Our ref: L01598902

22 October 2025

**65 HOLBEACH ROAD, SPALDING  
Application Nos H16-0882-25 & H16-0881-25**

BNG plan

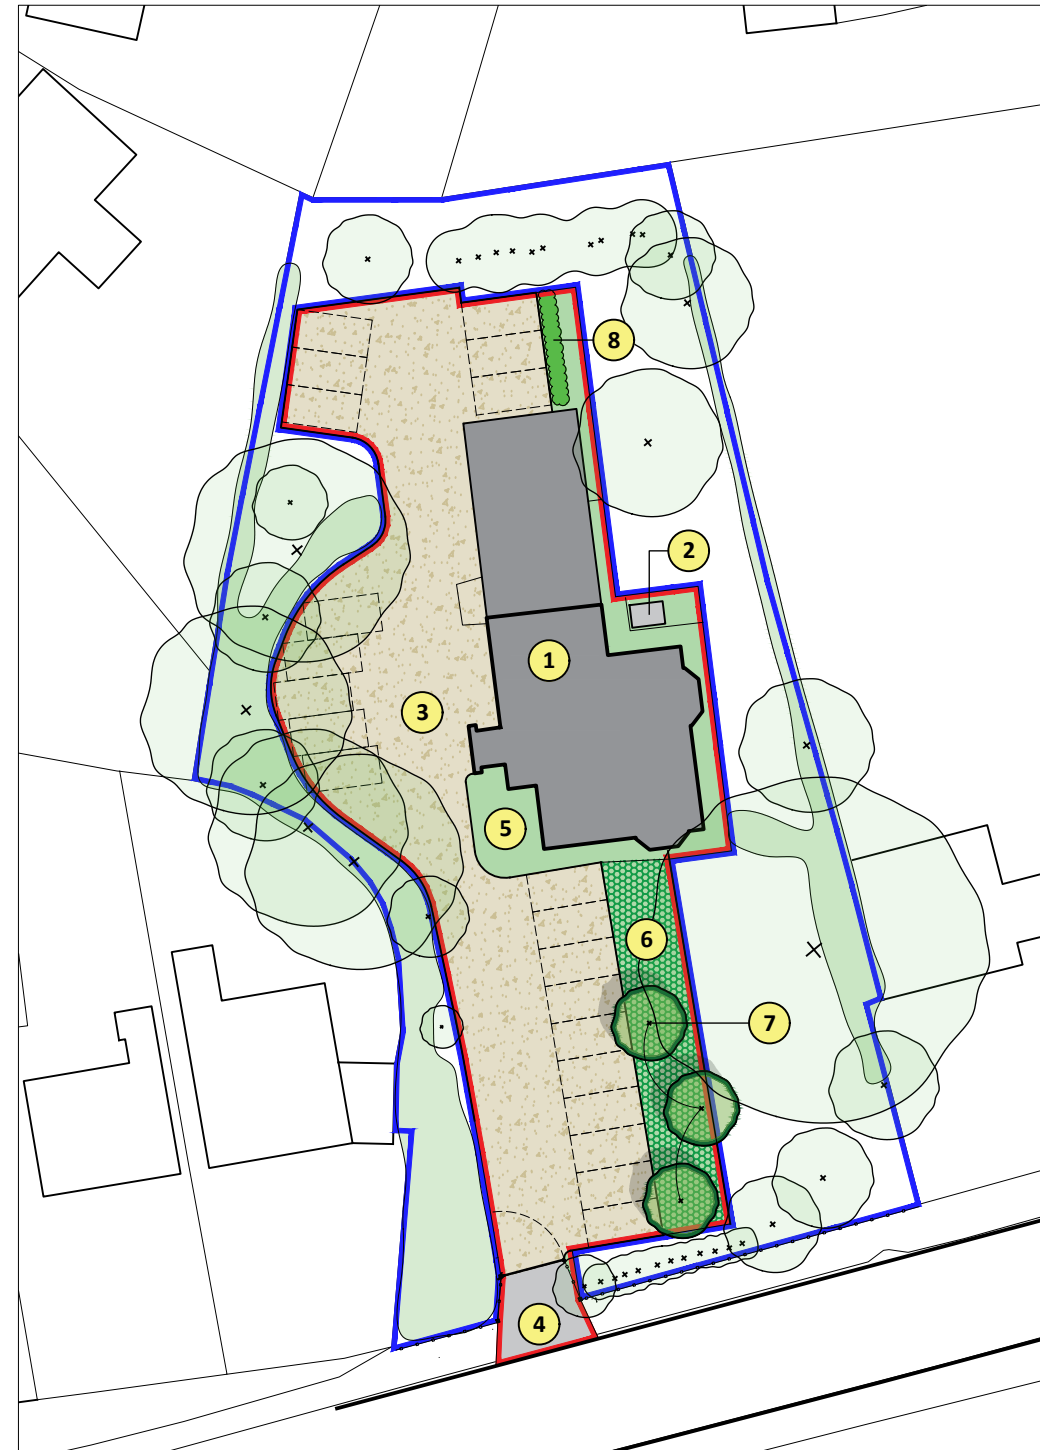
As part of the proposed conversion to use as a dental practice, the application seeks to build a new car parking area including the creation of ten spaces within the vicarage front (south) garden. We note the requirement for additional parking spaces to facilitate the change of use, however as outlined above, this is highly significant location and therefore any proposed development would need to be highly sensitive.

The proposed car parking spaces and associated alterations to the vicarage garden at the south would cause harm to the former vicarage and the Church of St Paul through eroding their historic setting. The car parking spaces would introduce hard landscaping to the setting of the vicarage and church and would create an incongruous visual intrusion to the historic character of this important group of George Gilbert Scott buildings.

We recommend that plans are amended to omit the proposed car parking spaces to the south of the vicarage. Historical research should be undertaken to understand the significance and historical evolution of the proposed development area, to then inform design. An options assessment outlining all options considered would also be useful.
